JOYFUL VIEW SUBDIVISION CONSTRUCTION DOCUMENTS A PART OF SECTION 33, TOWNSHIP 13 SOUTH, RANGE 63 WEST OF THE SIXTH PRINCIPAL MERIDIAN, COUNTY OF EL PASO, STATE OF COLORADO

PCD FILING NO. SF2231

CONSTRUCTION DOCUMENTS
COVER
SHEET CV 1

SHEET
GR

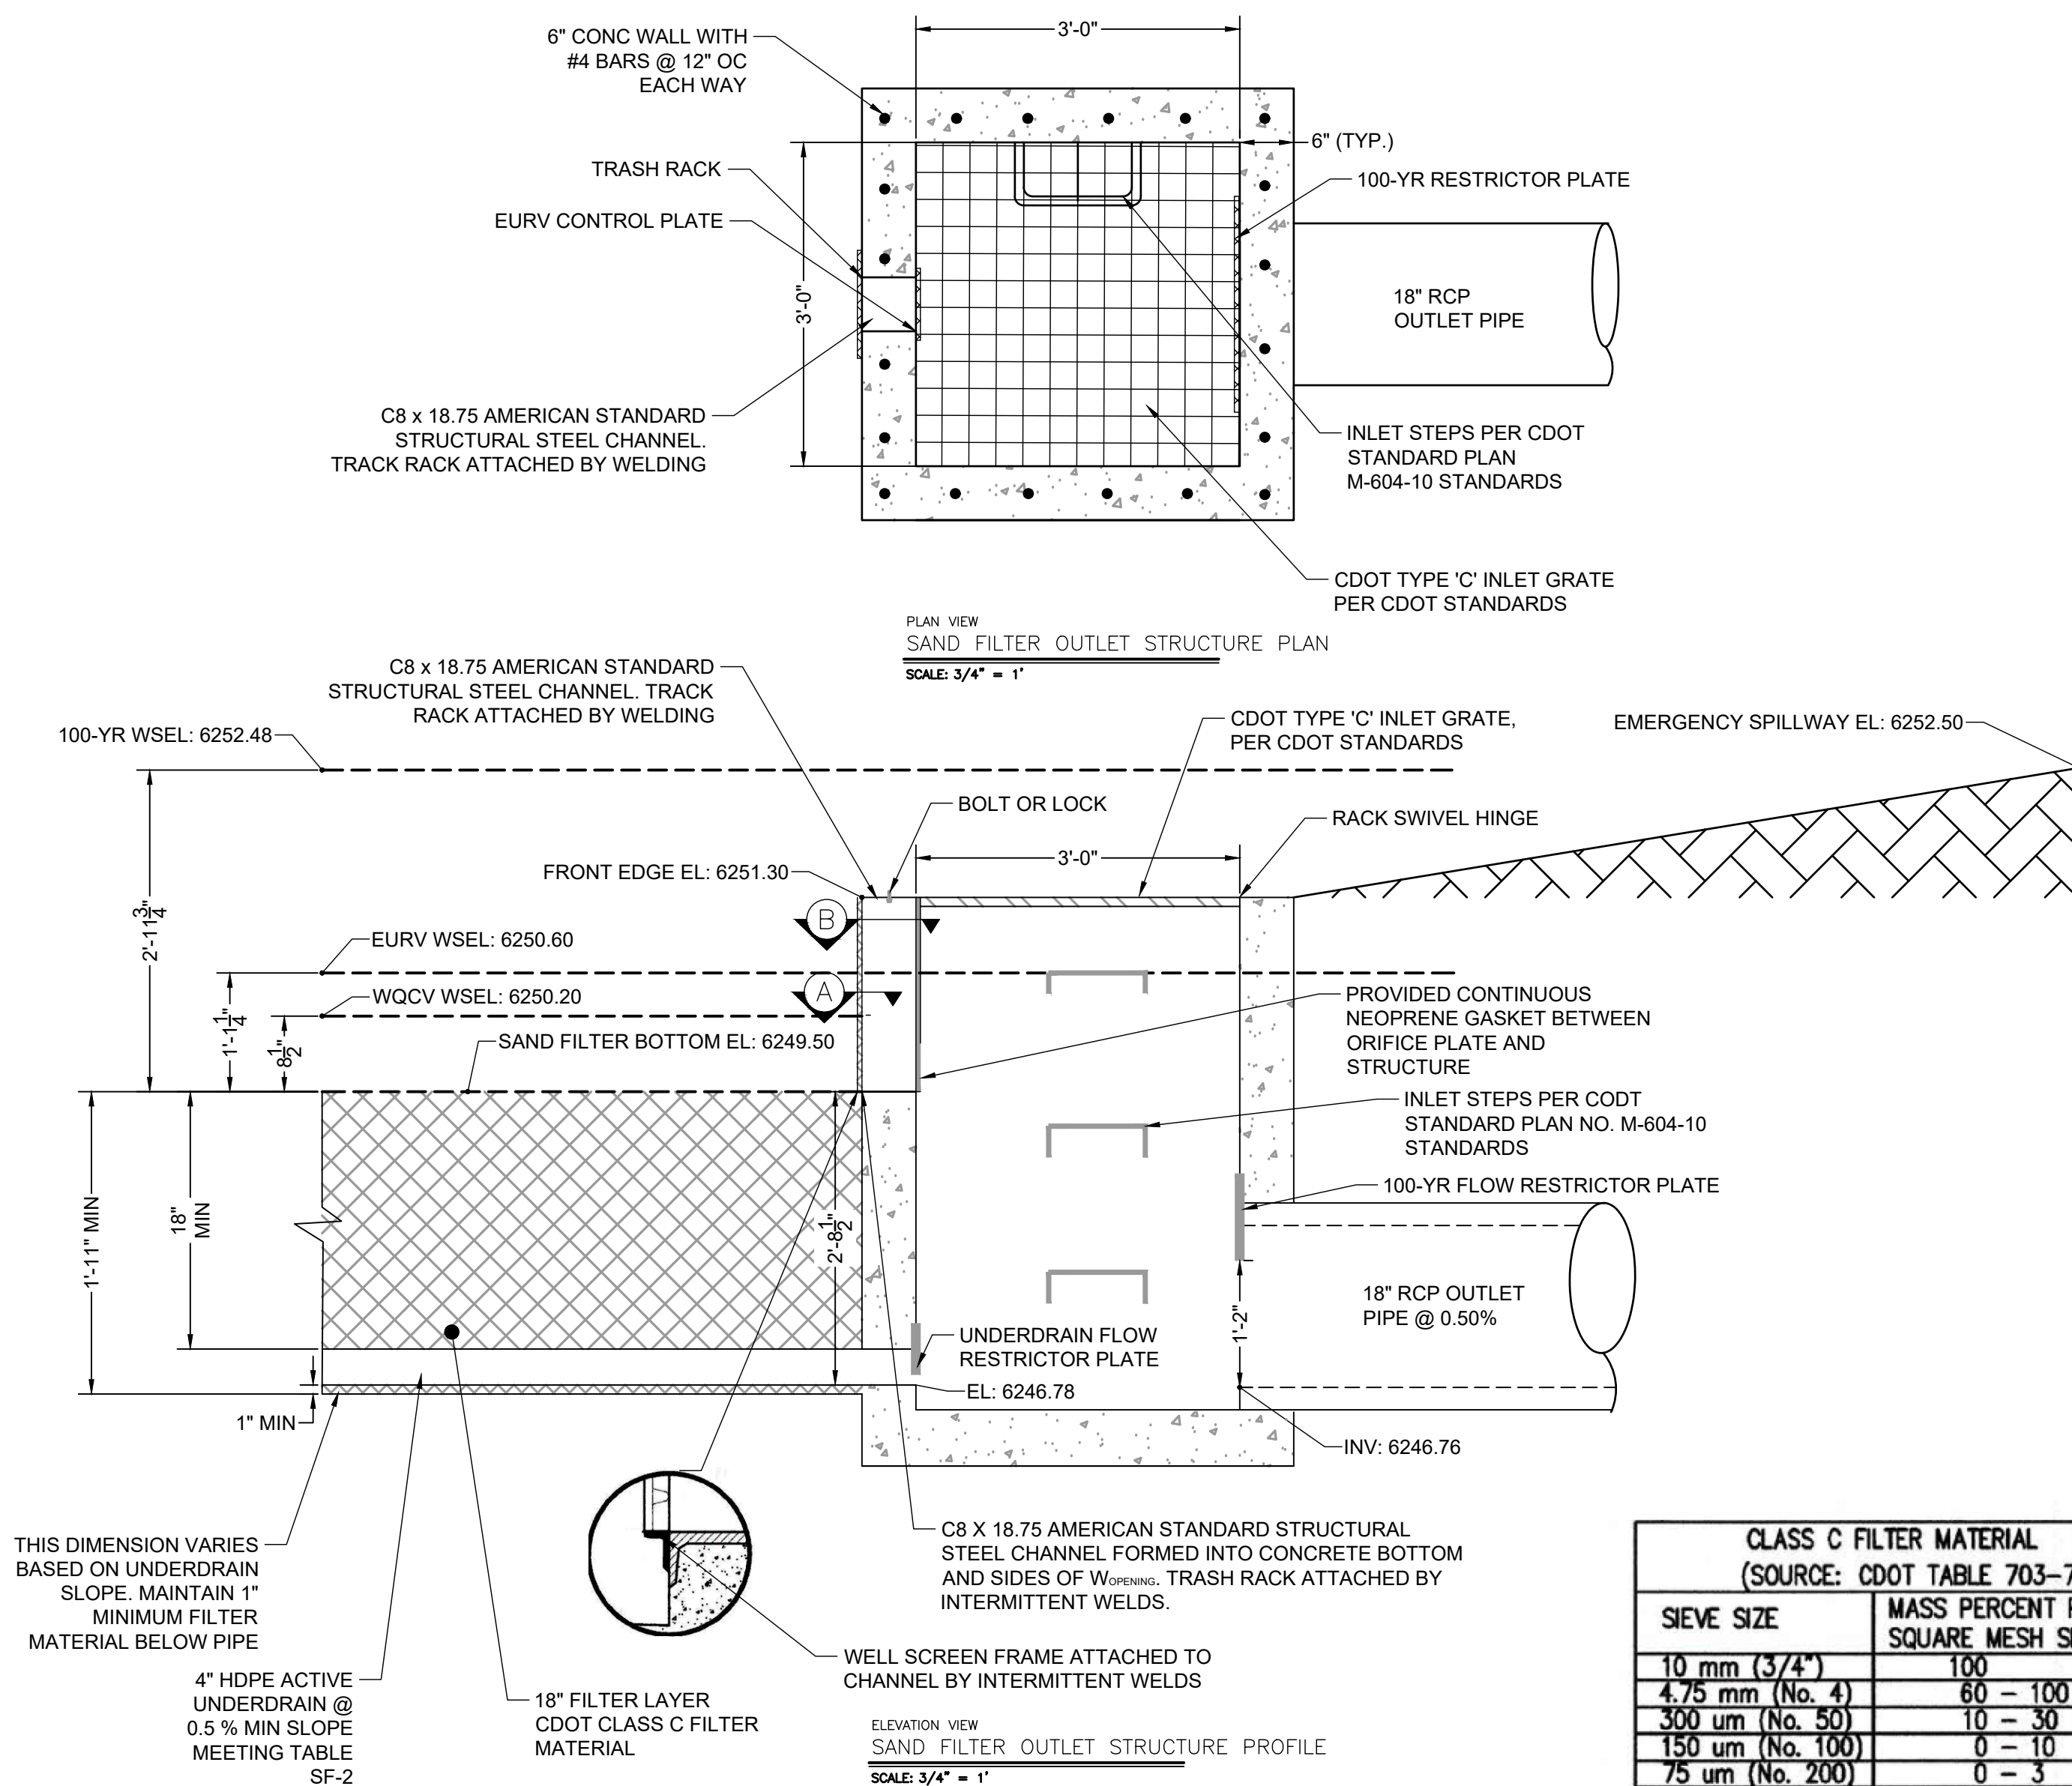
Which detail on DT-11? The Colorado Springs one? That one is specific to Forebays and does not really apply to anything on this sheet (GR8) besides maybe the Type II bedding under the soil riprap? Please clarify. And maybe just add that callout to the specific details on this sheet so the note about the COS detail can be removed.

Should match. Per FDR calcs should be 6252.50
